Online Comment

Application H16-0552-26
Location Land off Shakespeare Way Holland Park Spalding PE11 1GU
Proposal Erection of a 3-storey care home development with associated car parking, amenity space and ancillary structures

Name Mr David Jones - Chairman
Address Pedals 19 Ladywood Road Spalding PE11 2DA

Date Submitted 29-06-26
For/Against Comments

Client:	Country Court Care
Project Title:	Proposed care development at land off Shakespeare Way, Lincolnshire, PE11 1GU
Drawing Title:	Proposed Site Plan
Status:	STAGE 3
Date:	05.06.2026

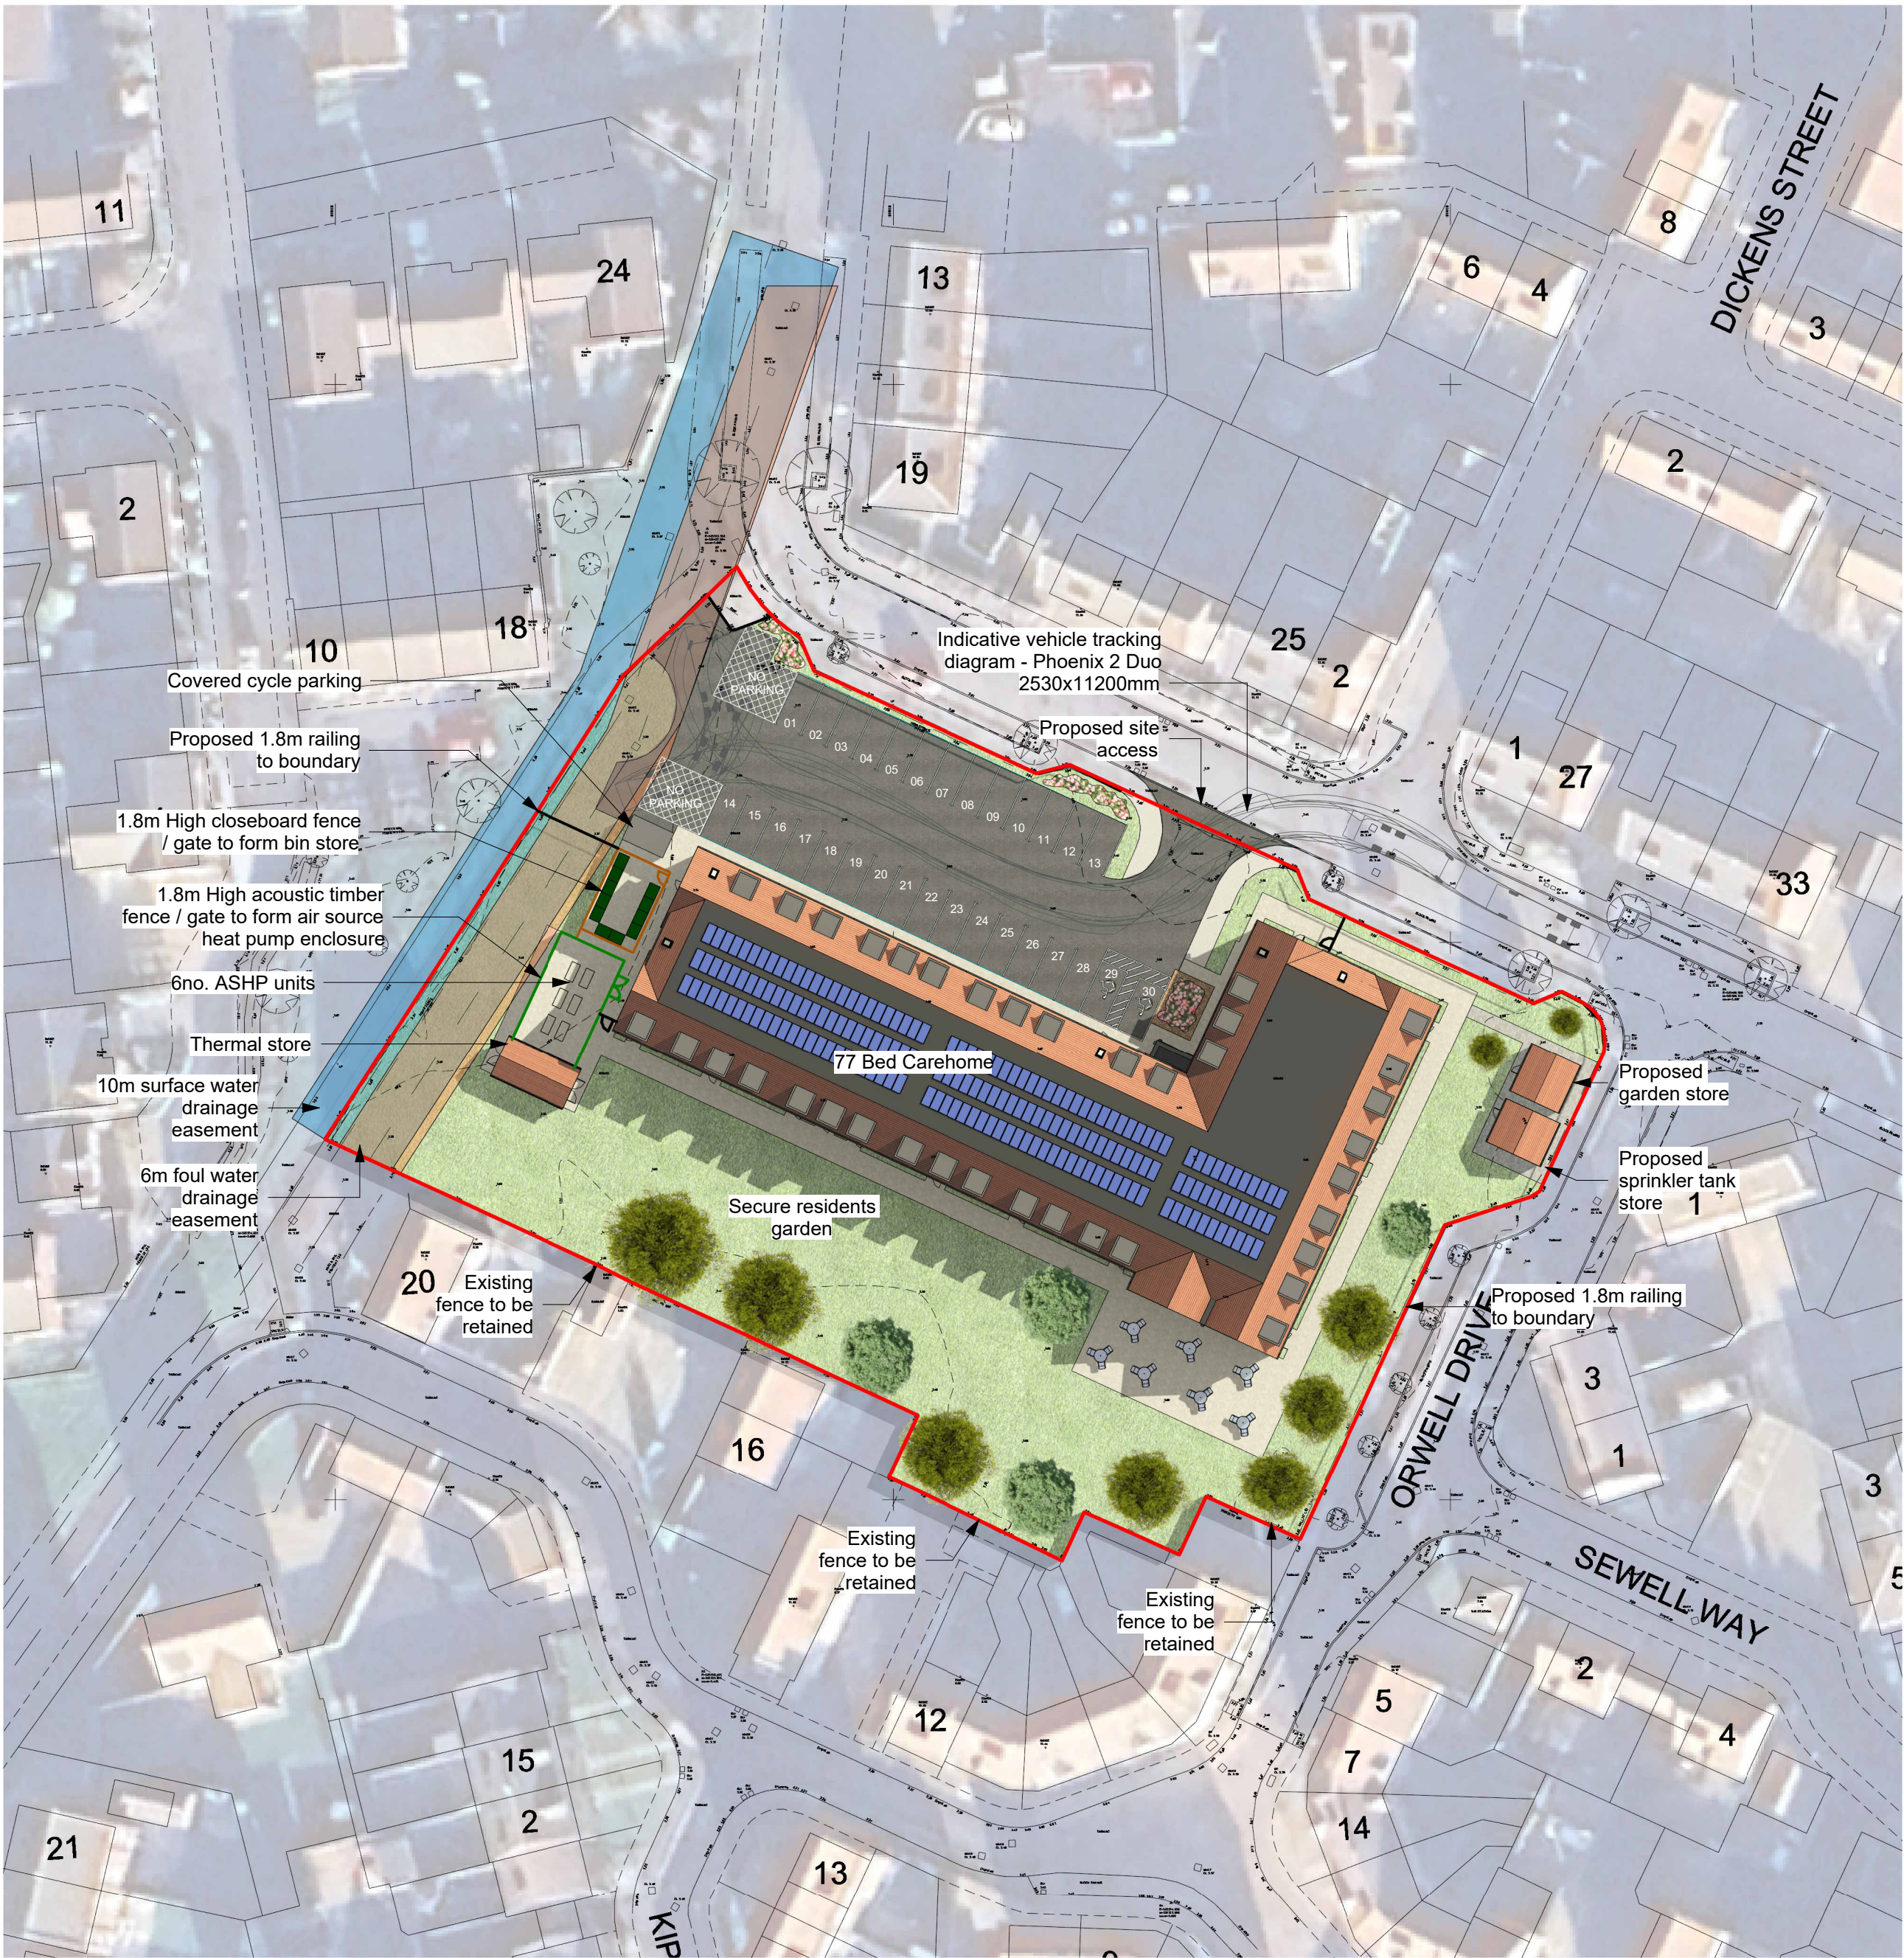
Please ensure that the proposed facilities for cycle storage and parking are in accordance with the local plan. If permission is granted, please impose conditions requiring the details of the cycle storage and parking to be submitted to and approved by the Council before the start of development and available for use before the development is occupied.
